Project Name:	Dearne Valley Parkway, Barnsley				
Client:	Gregory Property Group (GPG)				
Subject:	Response to Barnsley Highways Consultation Comments				
BGH Reference:	20-262-004.02				
Date:	05/09/2022				
Prepared by:	R. Donaldson	Checked by:	A. Bradley	Overview by:	M. Crabtree

Responses to BMBC August 2022 Consultation Comments

A	29.03.21	Site layout updated as per email 25.03.2021	DG	AB	-
Rev:	Date:	Amendment:	DRN	CHK	APR
Client:		GREGORY PROPERTY GROUP			
Project:		DEARNE VALLEY PARKWAY			
Drawing No:		20/262/TR/001		Revision: A	
Job No:		20-262		Date: 03.03.2021

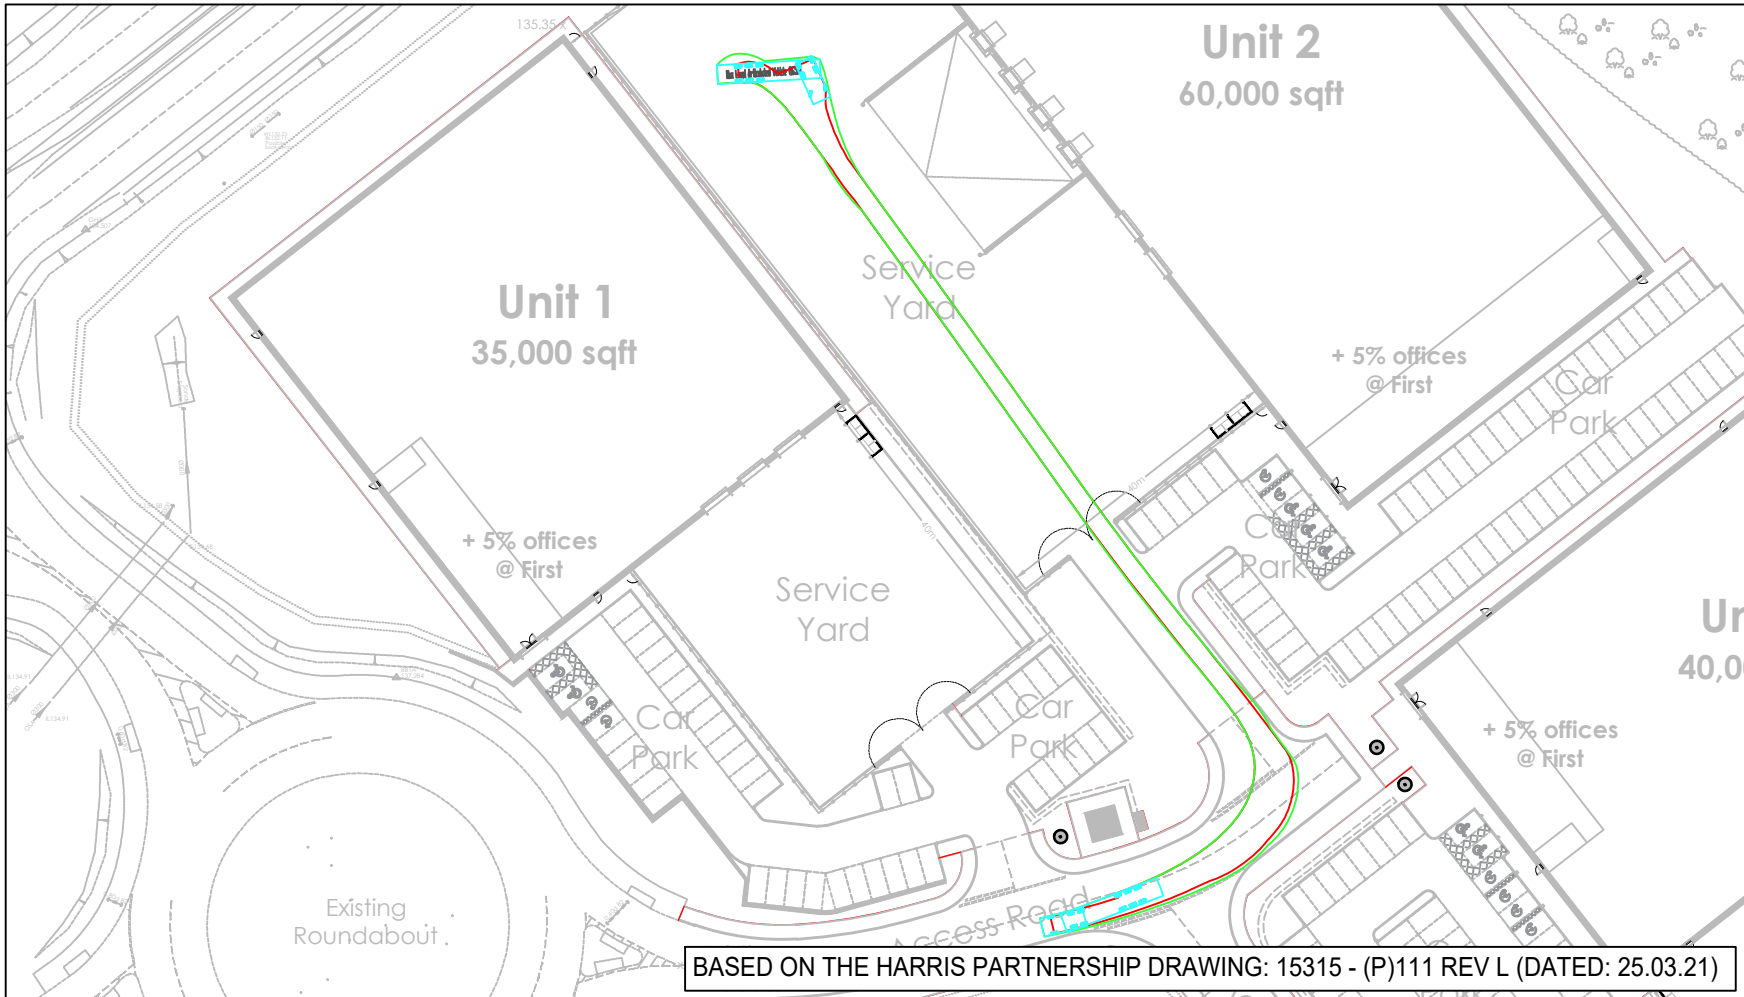
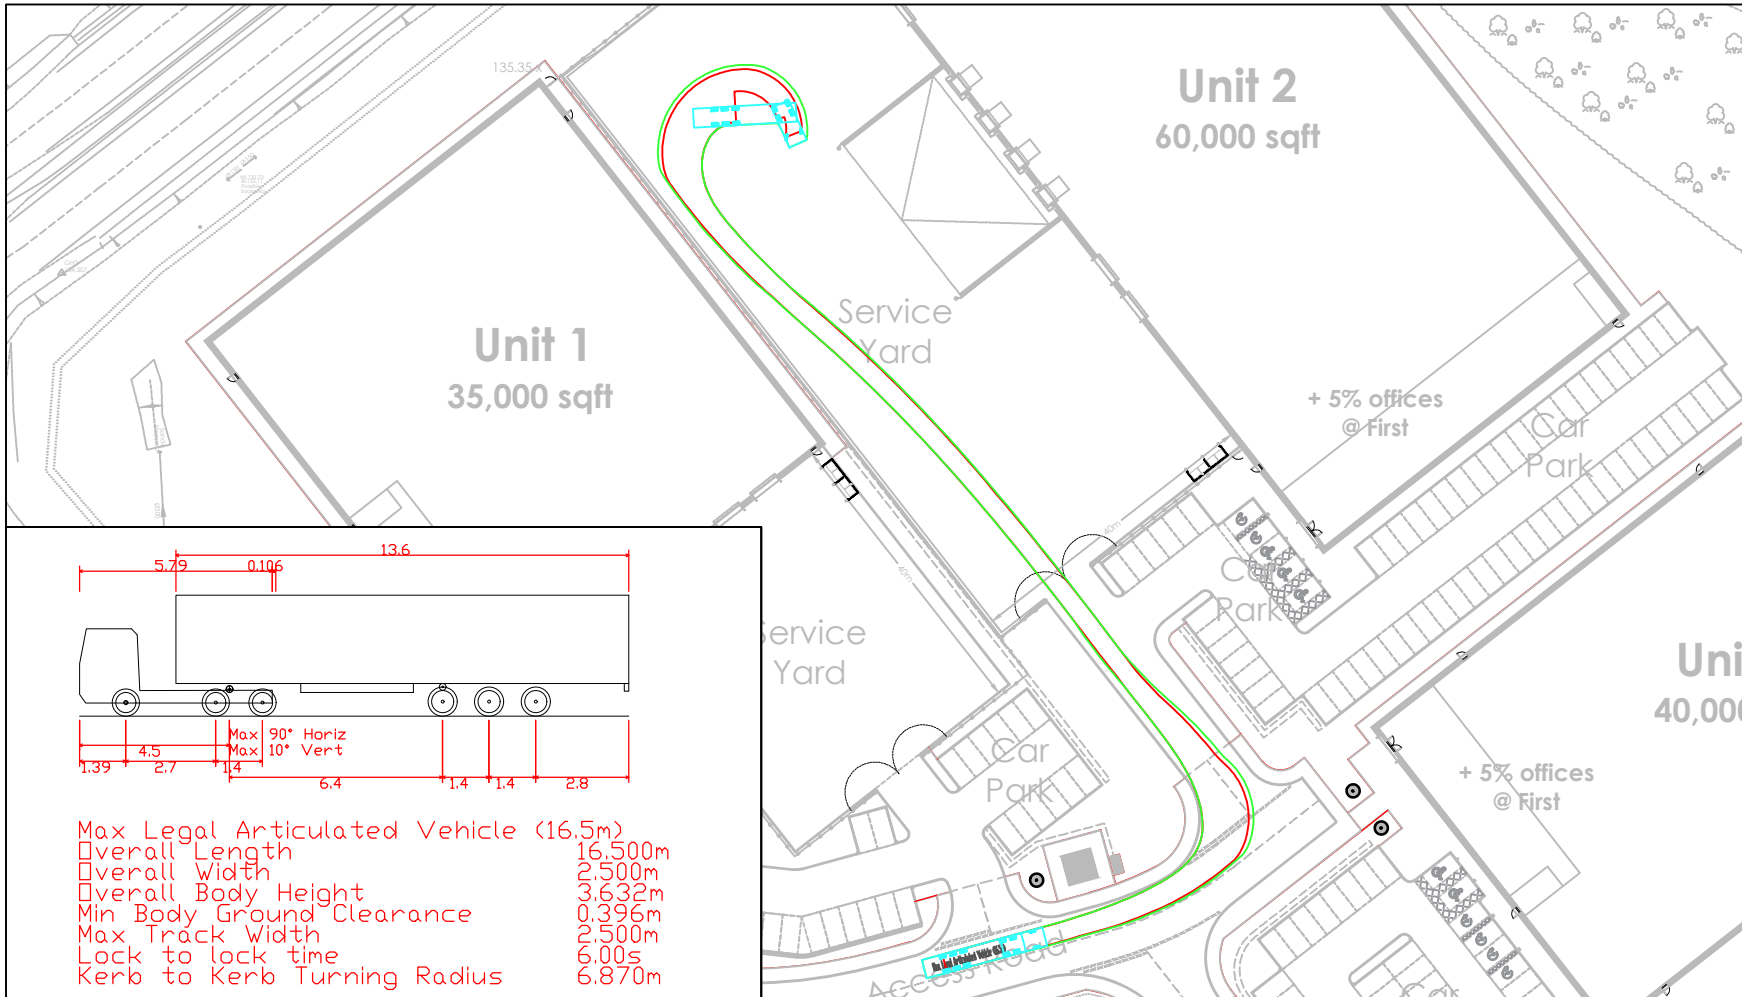
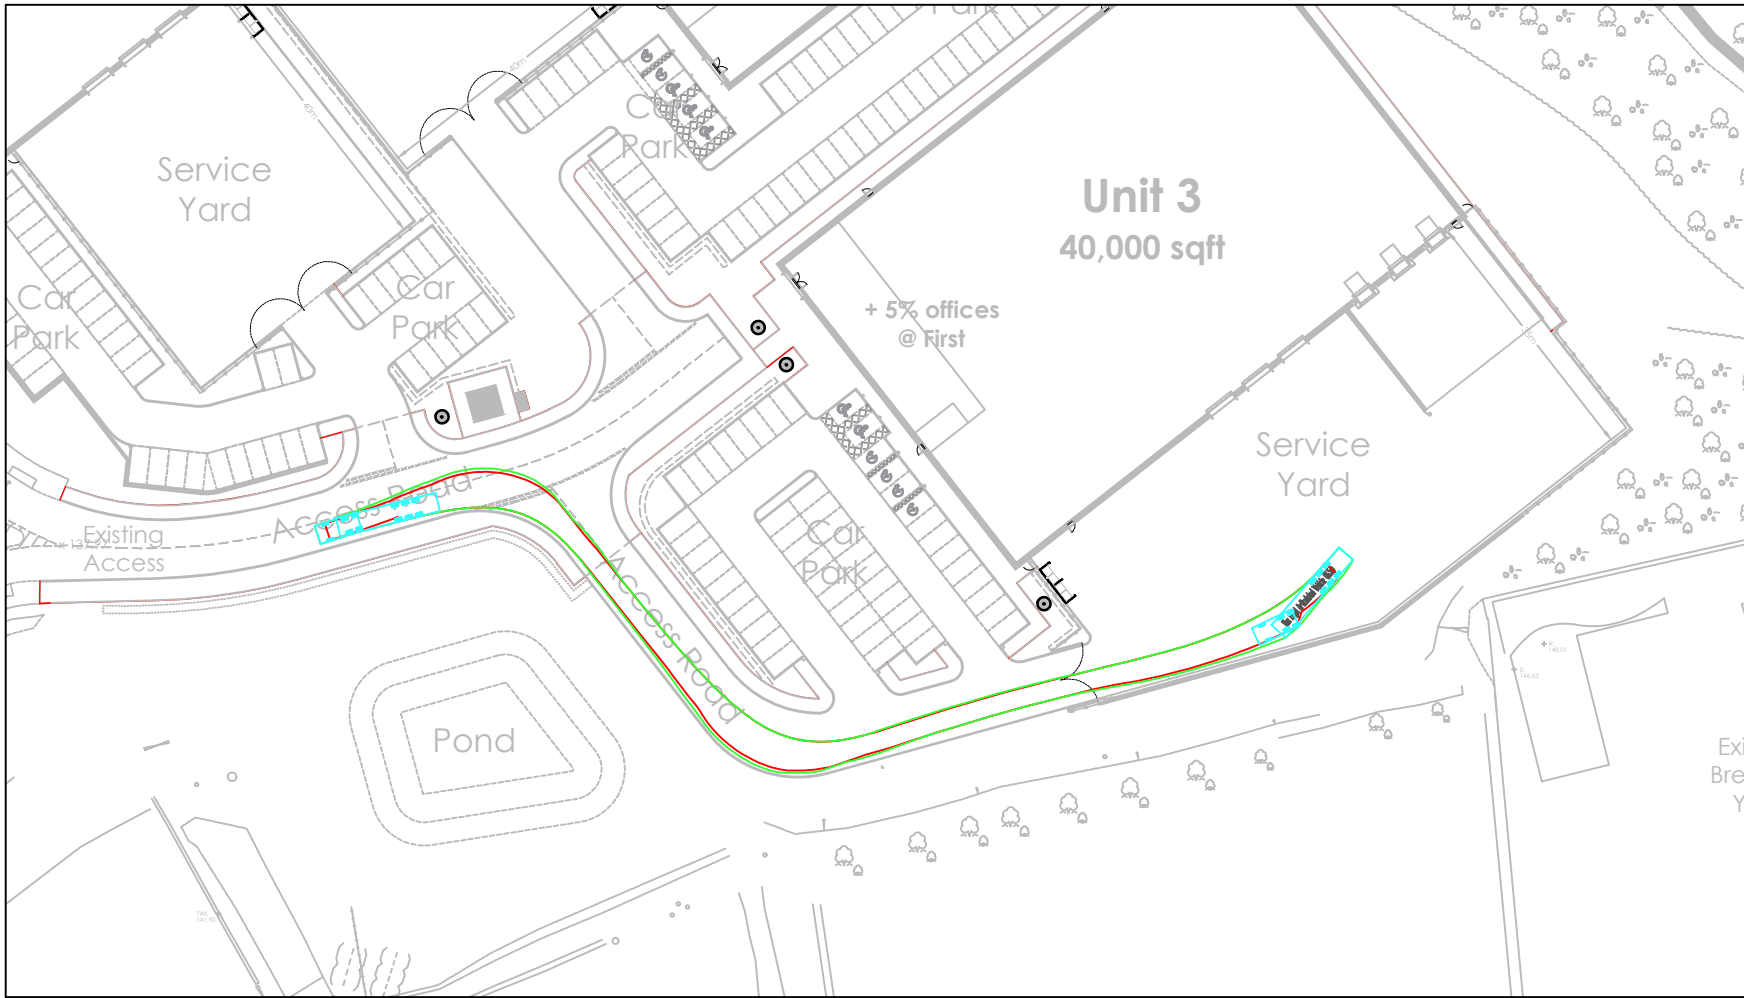
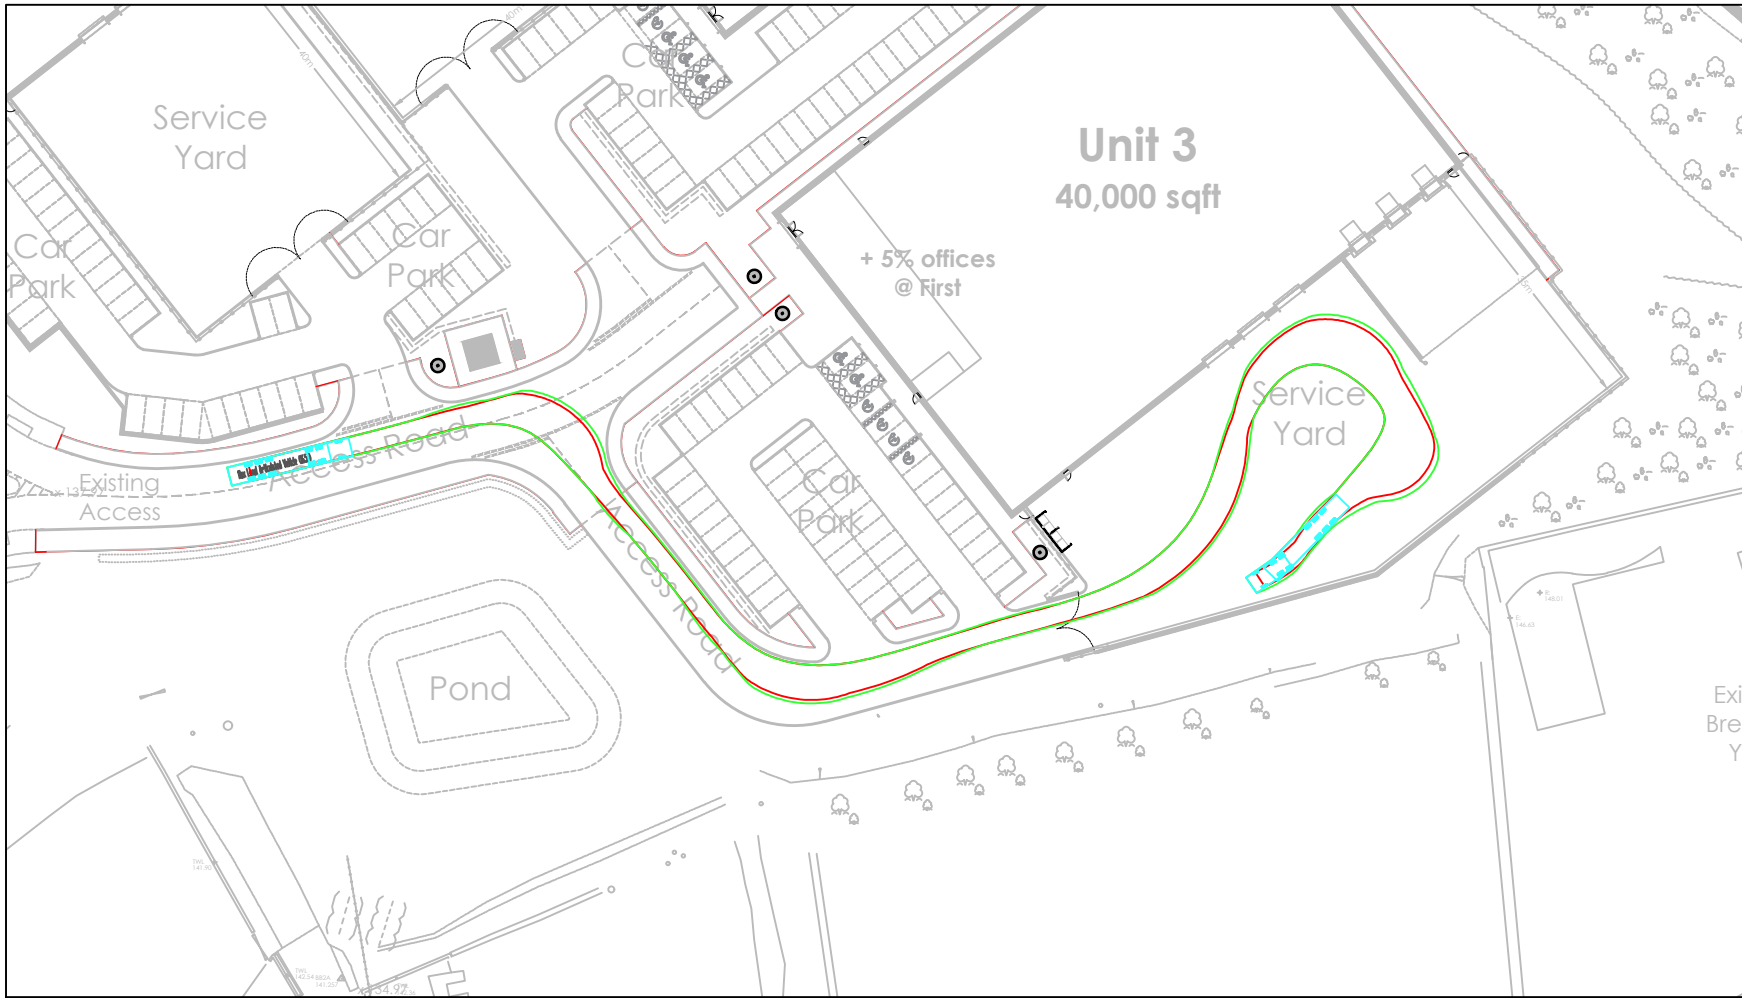
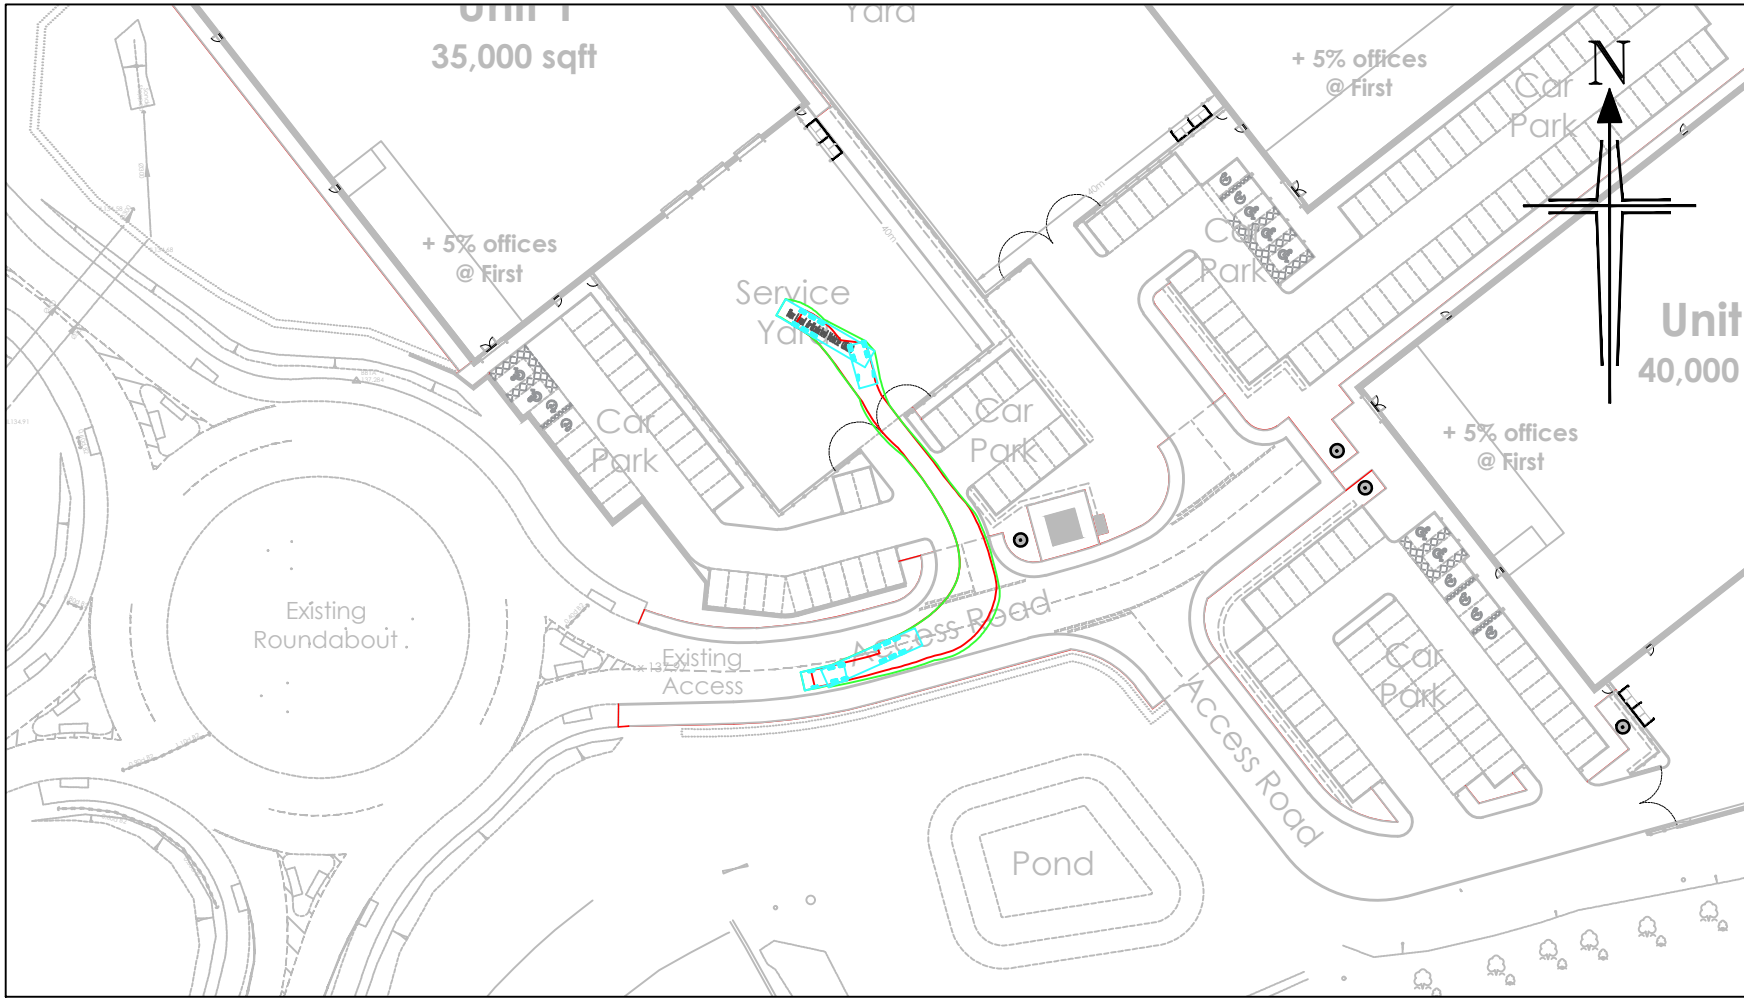
"The Transport Assessment appendix BGH 9 provides swept path analysis but will not be acceptable. A revised swept path analysis will be required that shows 2 x 16.5m articulated HGVs passing which should include a turning head."

7. Updated swept path analysis of the revised proposed site layout has been undertaken, which shows that a 16.5m articulated HGV can access the site and pass another HGV on the main site access road and the access road to Unit 3. The swept path analysis has been undertaken based on the proposed site layout with additional parking in the service yards, to demonstrate that there is sufficient room in the service yards for HGVs to manoeuvre with the additional parking in place. This is included at **Appendix BGH3** and can be summarised as follows:

- 20/262/TR/001 Rev C – swept path analysis of a 16.5m articulated HGV accessing and egressing the site using the existing roundabout junction with Sheffield Road;
- 20/262/TR/002 Rev C – shows that 16.5m articulated HGVs can access and egress each of the proposed plots;
- 20/262/TR/003 Rev B – shows that two 16.5m articulated HGVs can pass on the proposed Unit 3 access road;
- 20/262/TR/004 Rev B – shows that a 16.5m articulated HGV can manoeuvre within the proposed Unit 3 service yard;
- 20/262/TR/005 Rev B – shows that a 16.5m articulated HGV can manoeuvre within the proposed Unit 2 service yard;
- 20/262/TR/006 Rev B – shows that a 16.5m articulated HGV can manoeuvre within the proposed Unit 1 service yard; and
- 20/262/TR/007 Rev A – shows that two 16.5m articulated HGVs can pass each other on the main access road through the site.

8. HGVs will be able to turn within the proposed service yards, therefore a separate turning head is not required. Should any vehicles enter the site mistakenly, which is unlikely, they can either turn around within one of the proposed service yards or an alternative turning facility would be available using the accesses to Units 2 and 3.
